Ref: 6/2018/0340/LB
Date: 24/04/2018

HISTORIC BUILDINGS AND CONSERVATION ADVICE

RE: 11 Wilkins Green Lane, Hatfield, AL10 9RT

The application is for the erection of a garden room at 11 Wilkins Green Lane, Hatfield.

OECD CANOPY GARDEN ROOM
 A. CHARLTON
 TORILLA
 11 WILKINS GREEN LANE
 HATFIELD AL10 9RT

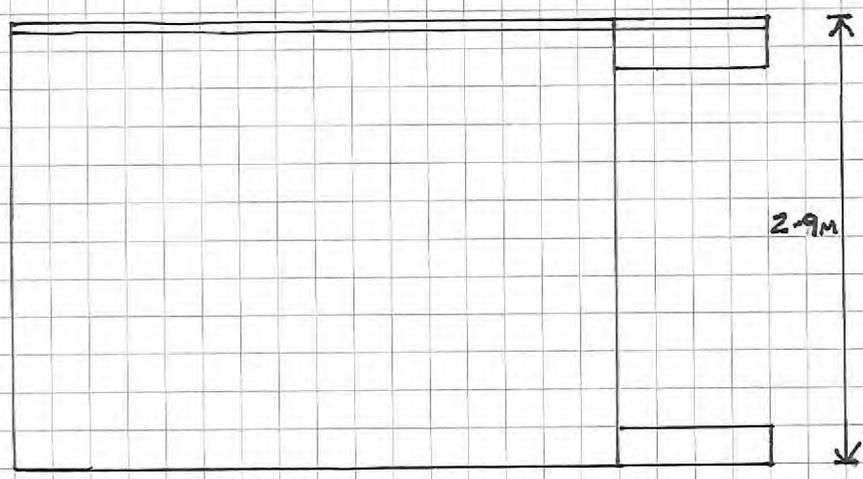
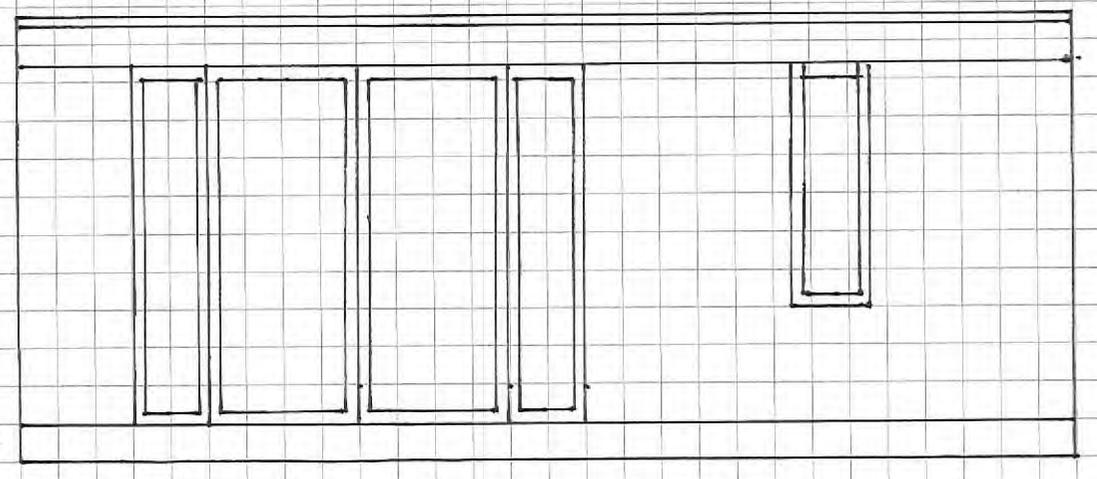
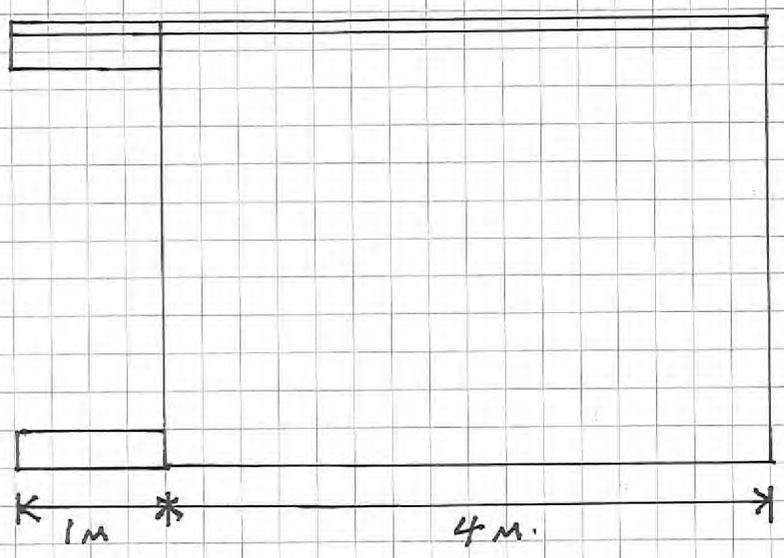
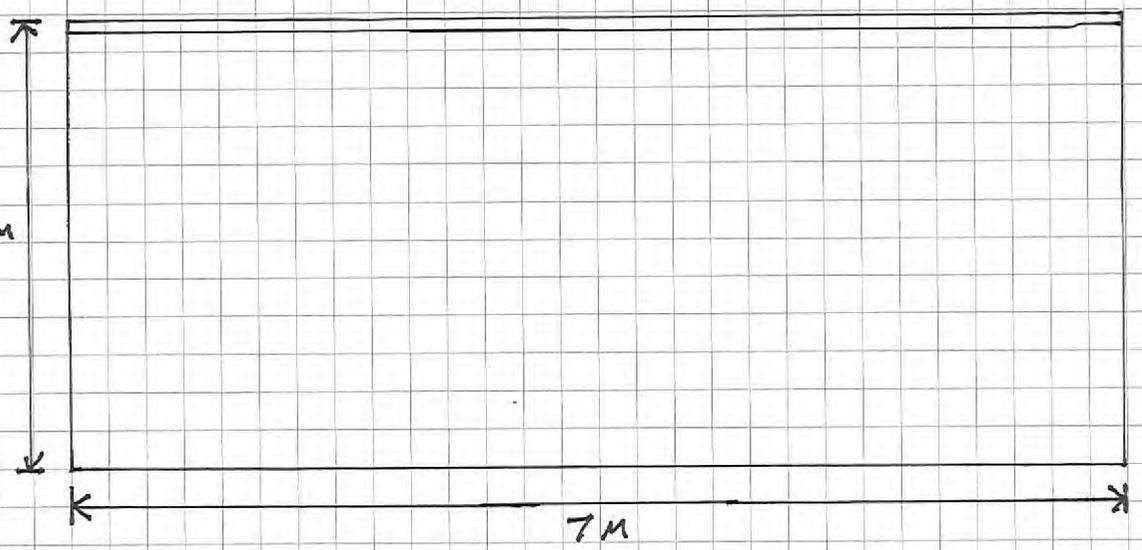
It is noted that the application states that the window and doorframes would be of grey aluminium, however the garden rooms details submitted outline that the garden room would have PVC-U window and doorframes. PVC-U windows and doors would not be considered appropriate and therefore grey aluminium should be used.
